From: Amanda Scholes <Amanda.Scholes@arun.gov.uk> **On Behalf Of** Planning.Responses
Sent: 14 July 2020 11:26
To: Planning Scanning <Planning.Scanning@arun.gov.uk>
Subject: FW: FW: FW: Planning Consultation on: BN/57/20/DOC

Please upload onto Ocella the email trail below which is the consultation response from **ADC Drainage Engineers** to discharge of condition application **BN/57/20/DOC** regarding The Lillies, Yapton Road, Barnham.

I have received the following email and attachment from John Freeman regarding discharge of condition application **BN/57/20/DOC** regarding the Lillies, Yapton Road, Barnham.

FILTER DRAIN BAGWORK HEADWALL

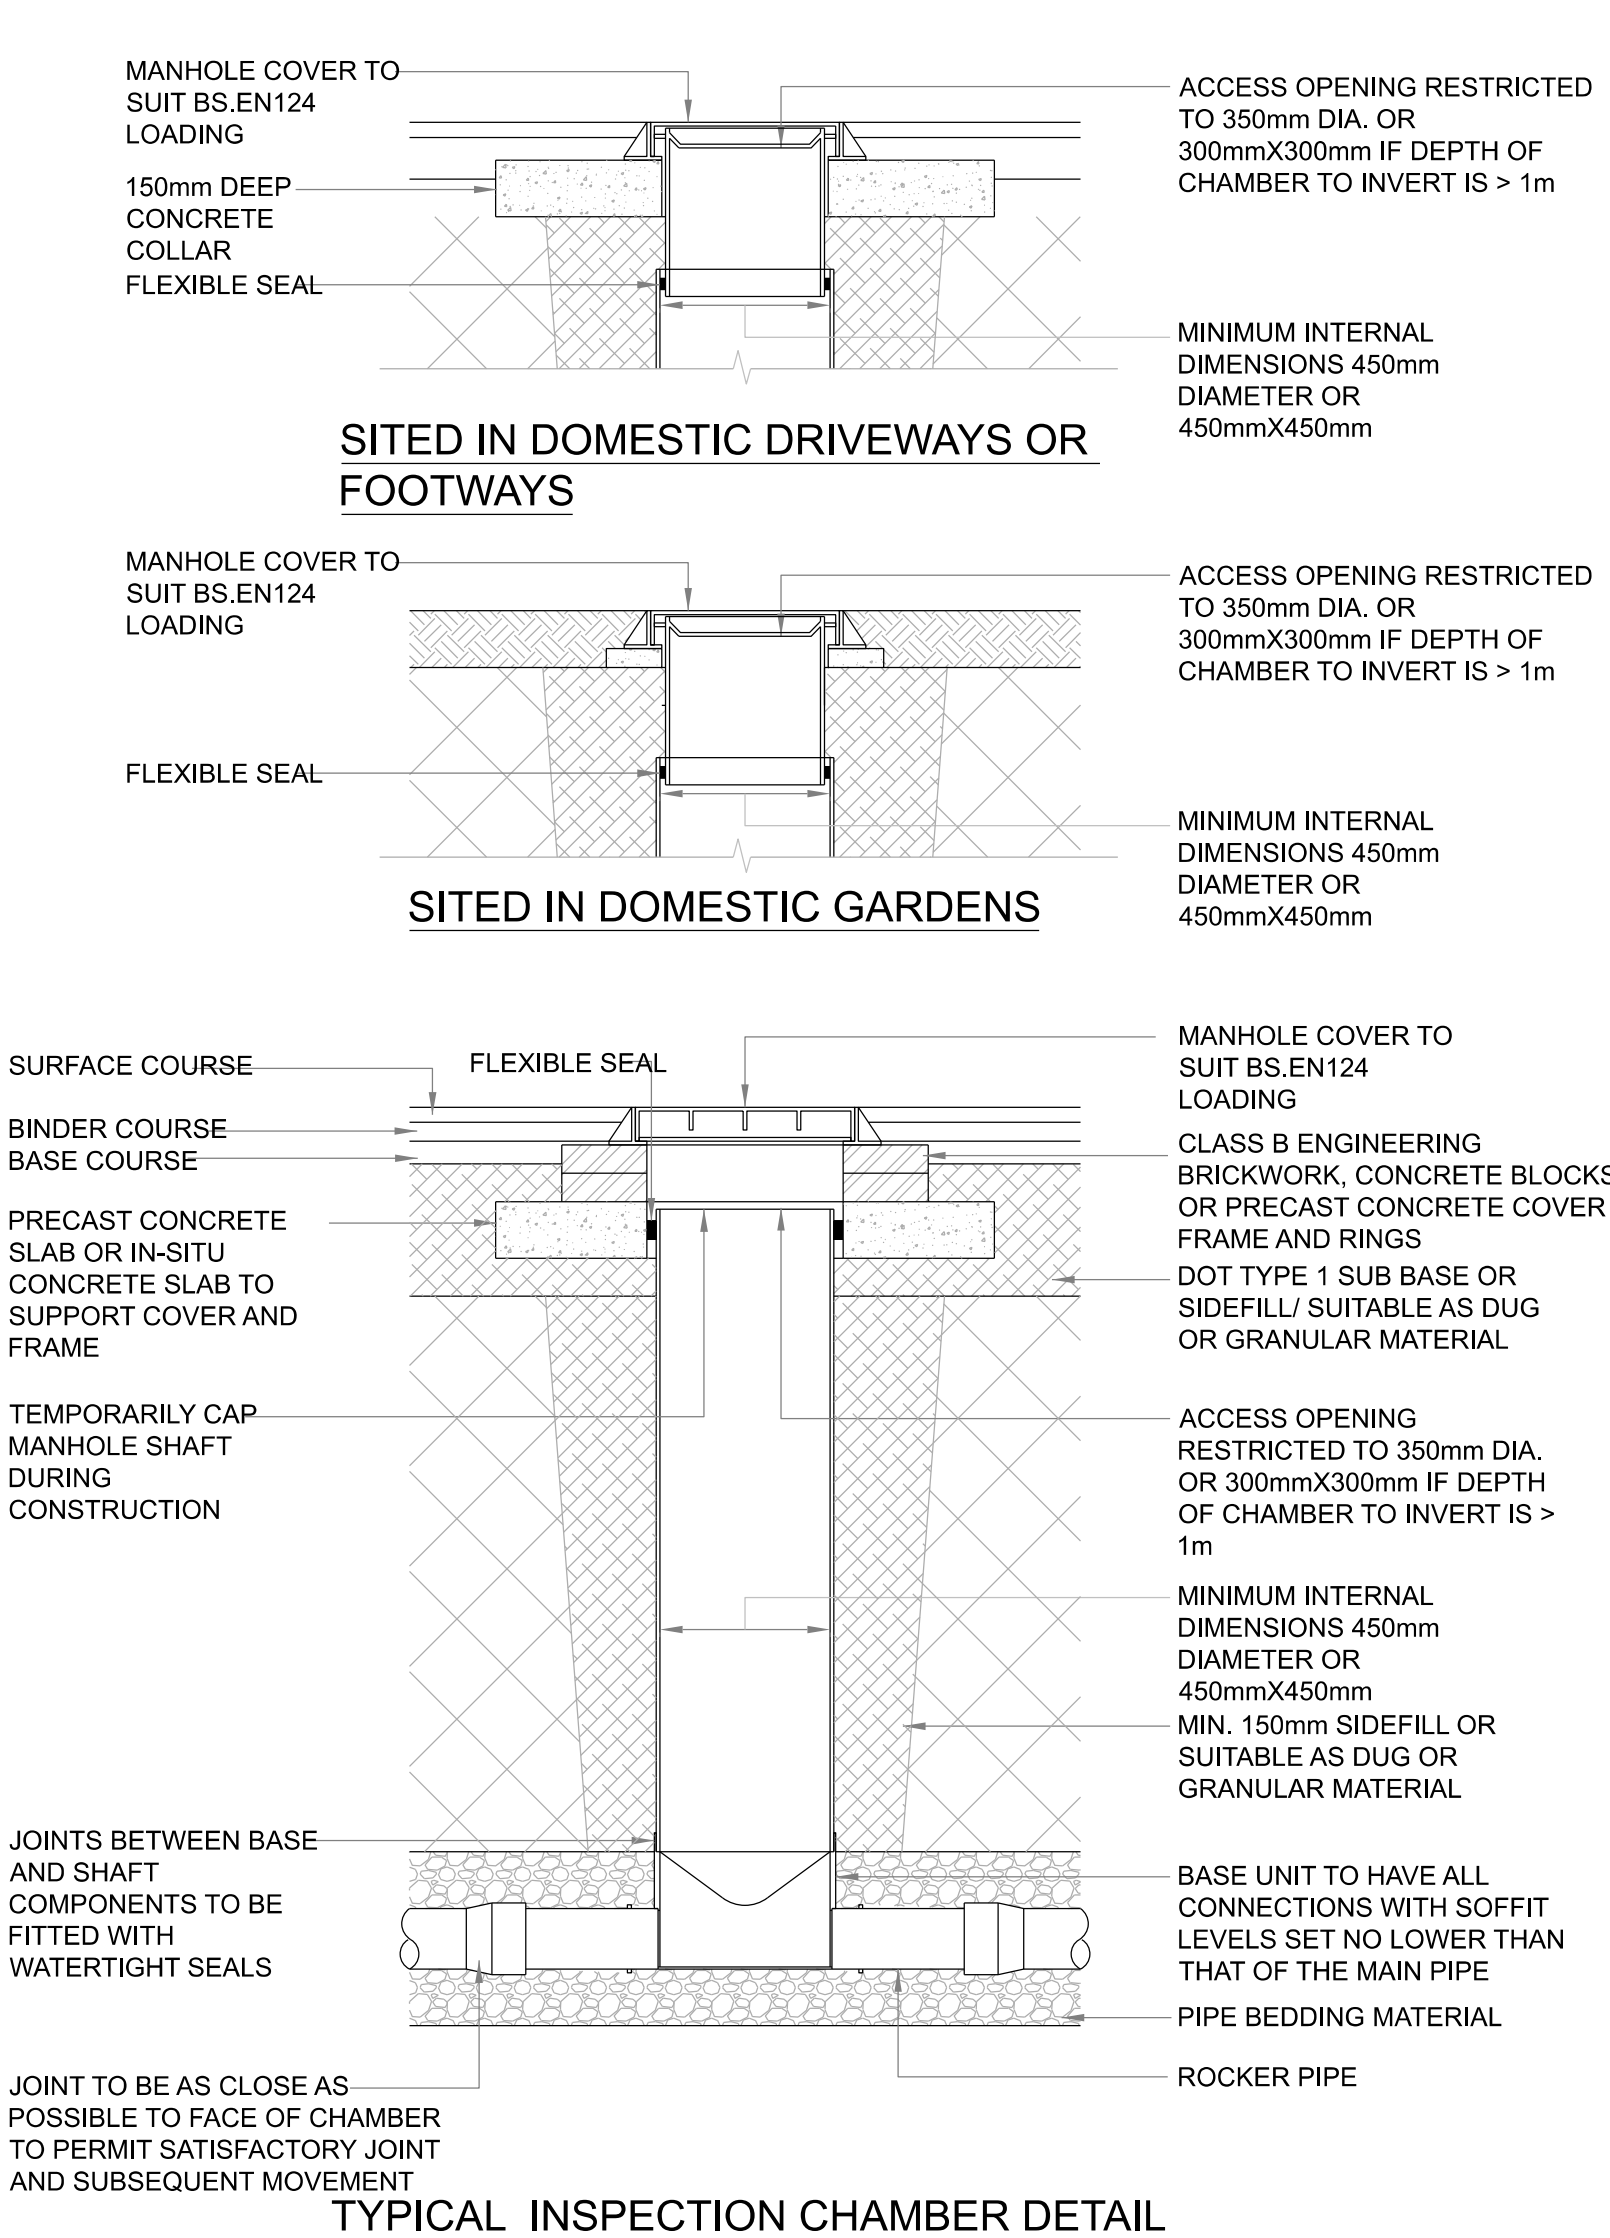
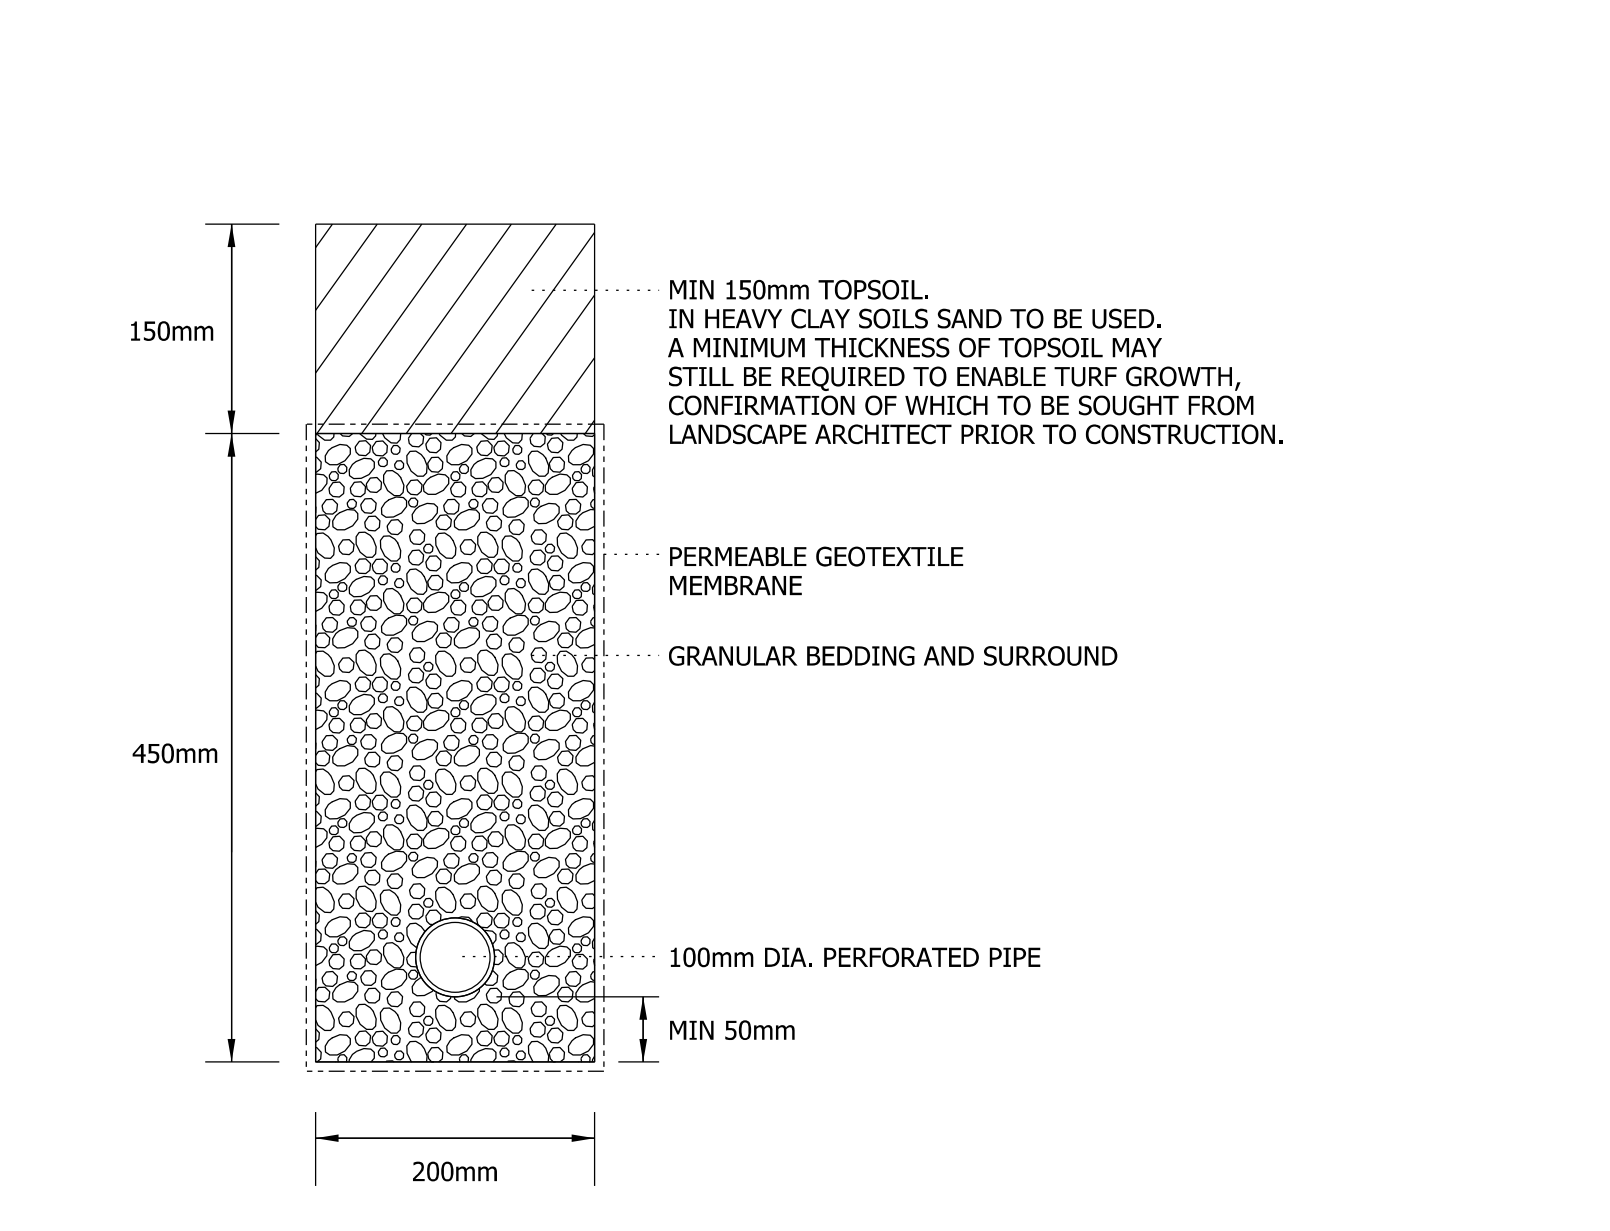
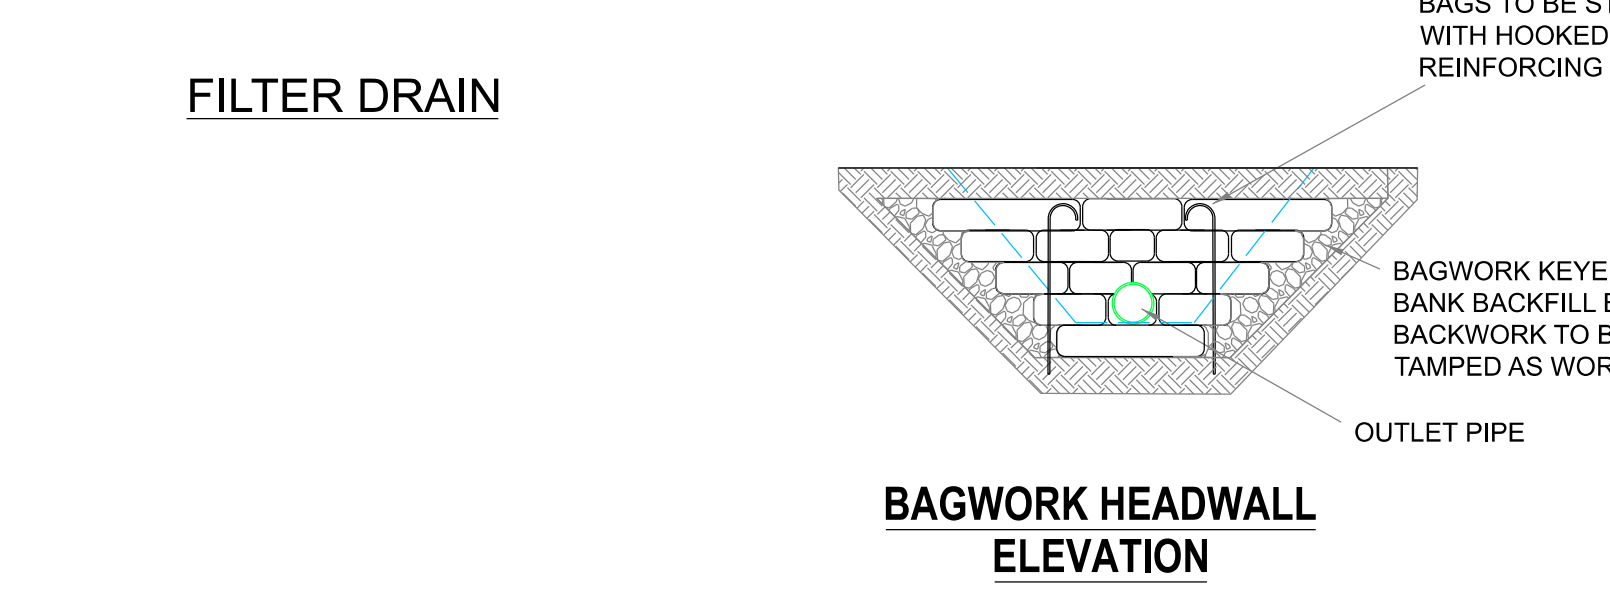
37. Await Southern Waters response.
38. Filter drain noted, however it needs to extend up to and including the rear of plot 12. Specify a 100mm pipe as opposed to 50mm. Rodding eye or manhole access required at head of run. Simple concrete bag headwall to be in accordance with the enclosed detail. *Adjusted*

SCALE	1:200 @ A1	DATE	JULY 2019
DRAWN	WFN	CHK	CLS
DRAWING NO.	17748-BARN-5-600	REV	G
TITLE	YAPTON ROAD BARNHAM		
DETAILS	ENGINEERING LAYOUT SHEET 1

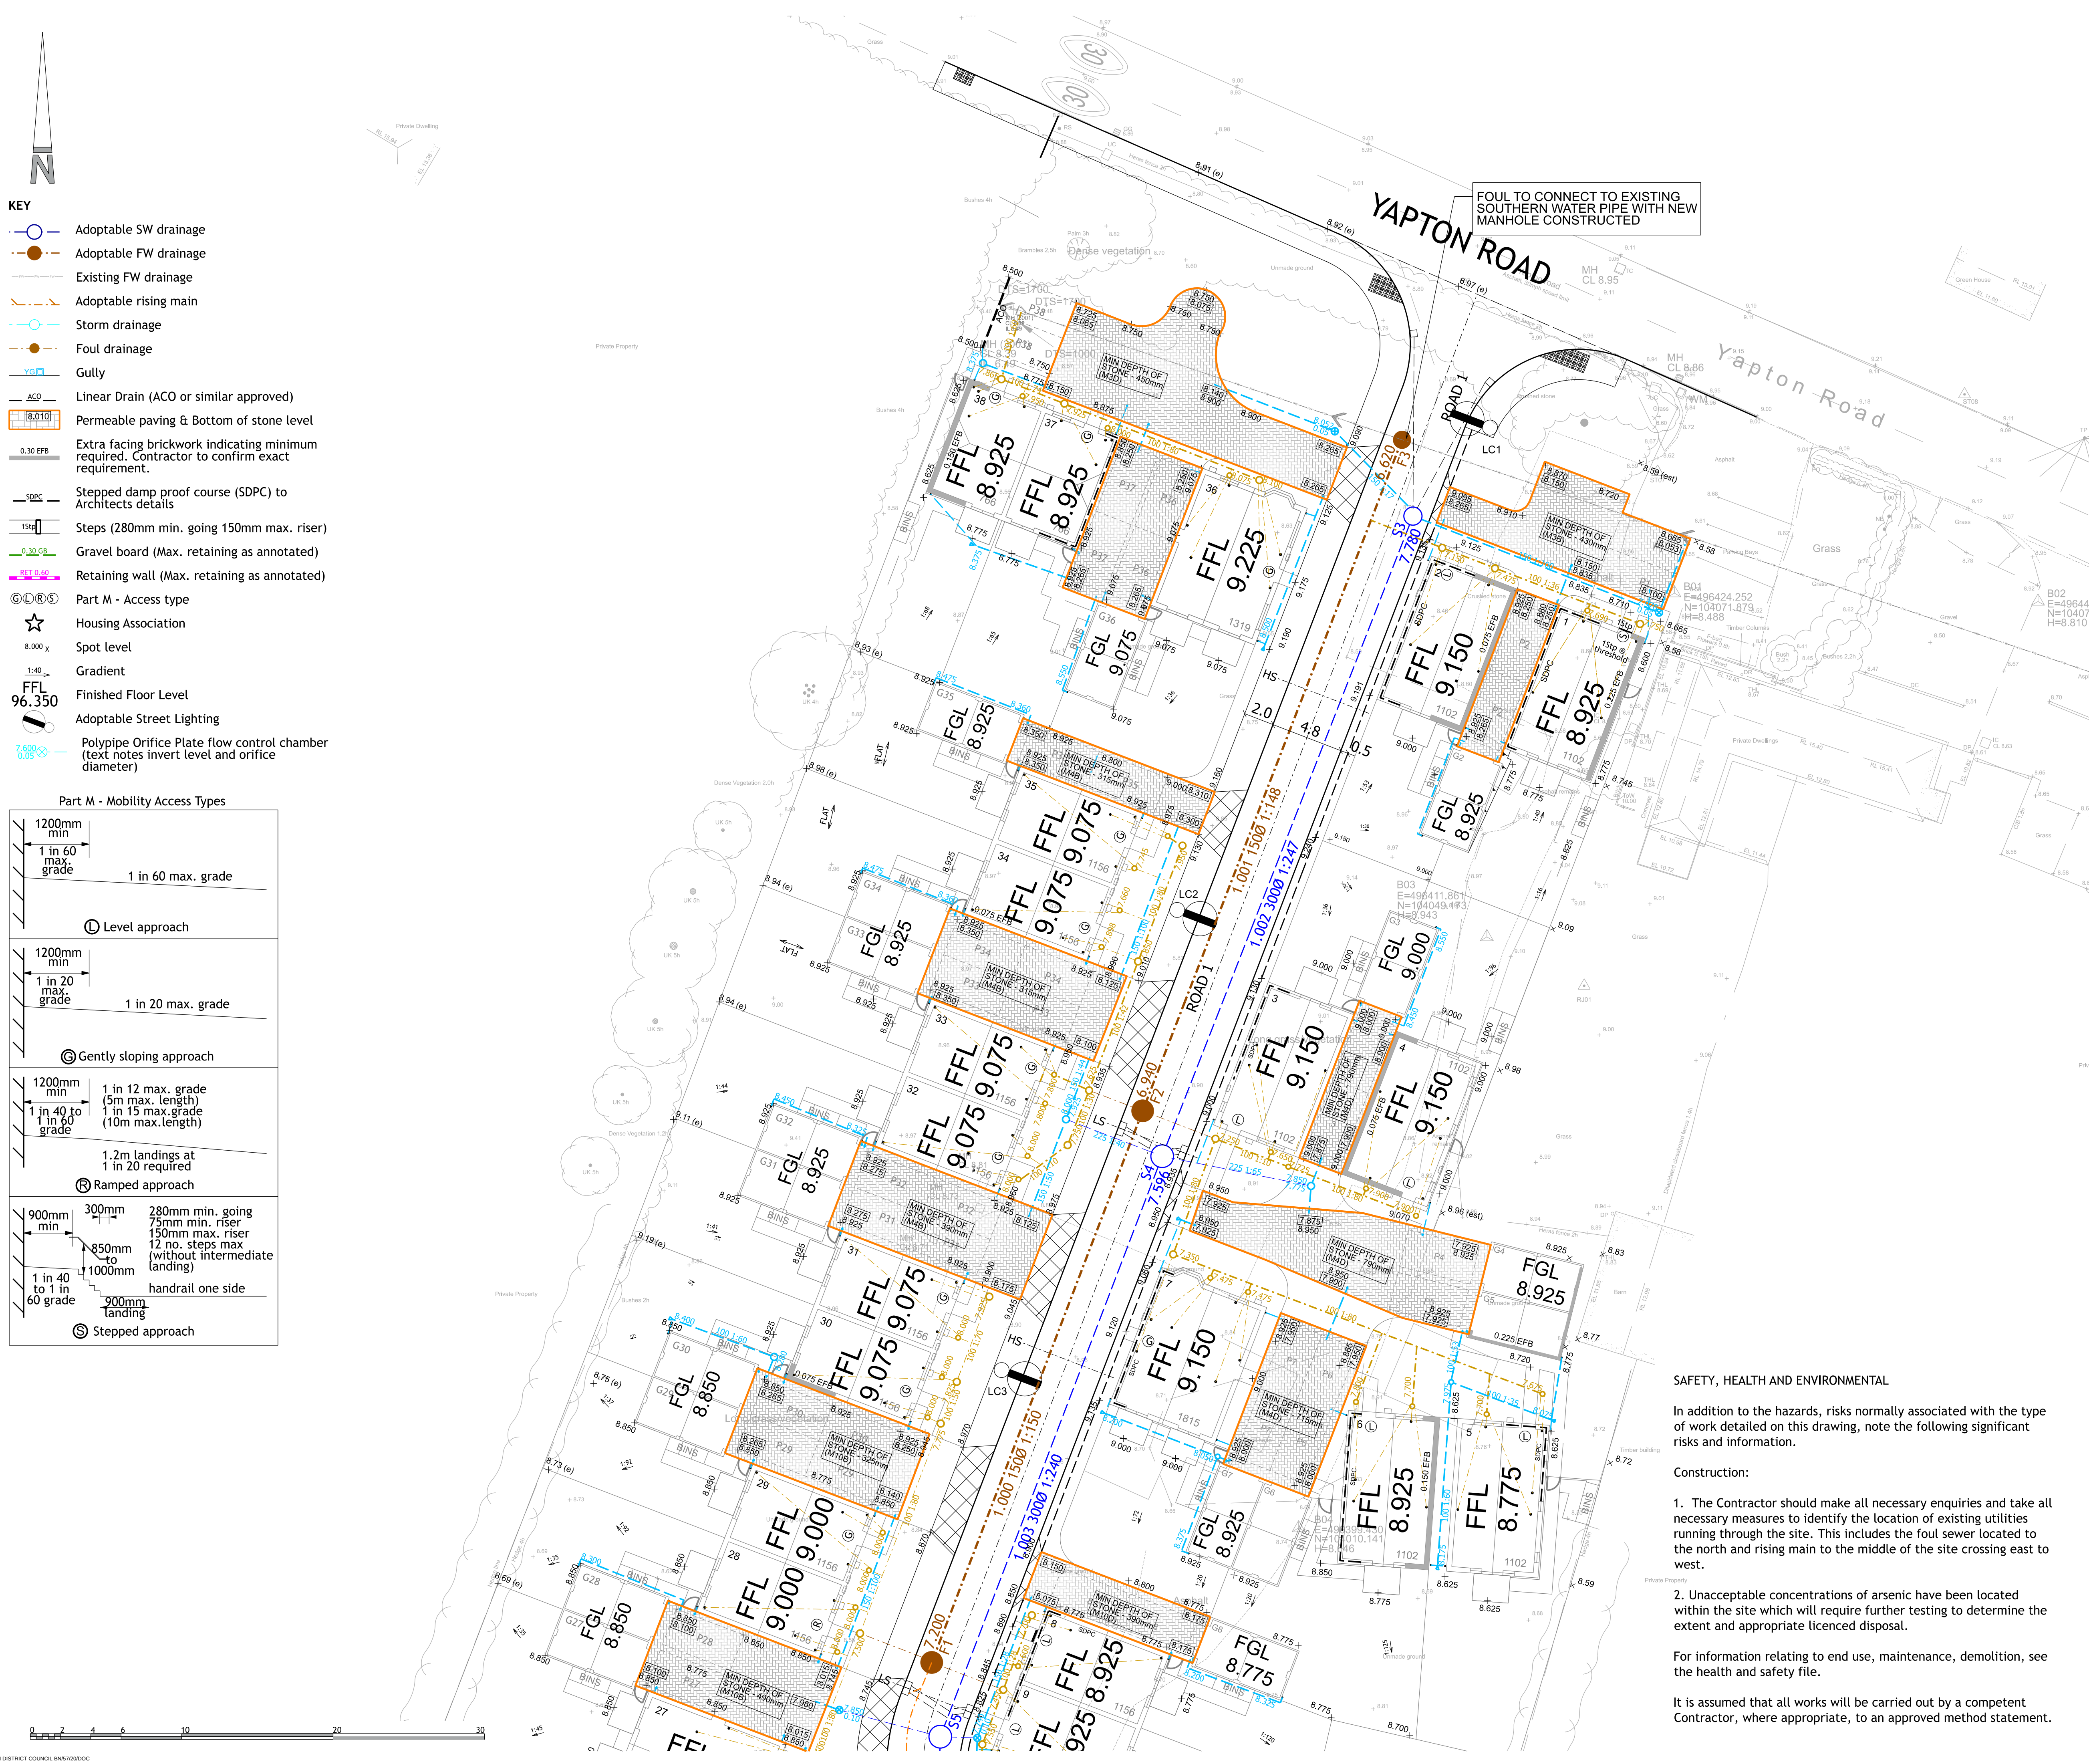
16. Indicate the depth of pipe cover to suit each bedding type detail, on the drawing. *Amended*
17. -
18. -
19. Ok (Drawing 601 amended), drawing 600 needs to be too. *Amended*

26. -
27. -
28. Ok
29. -
30. Ok
31. -
32. -
33. Ok
34. -
35. Ok
36. Not connecting the 150mm pipe at soffit to soffit level is bad practice. Please rectify, irrespective of the S104 application. *Adjusted*
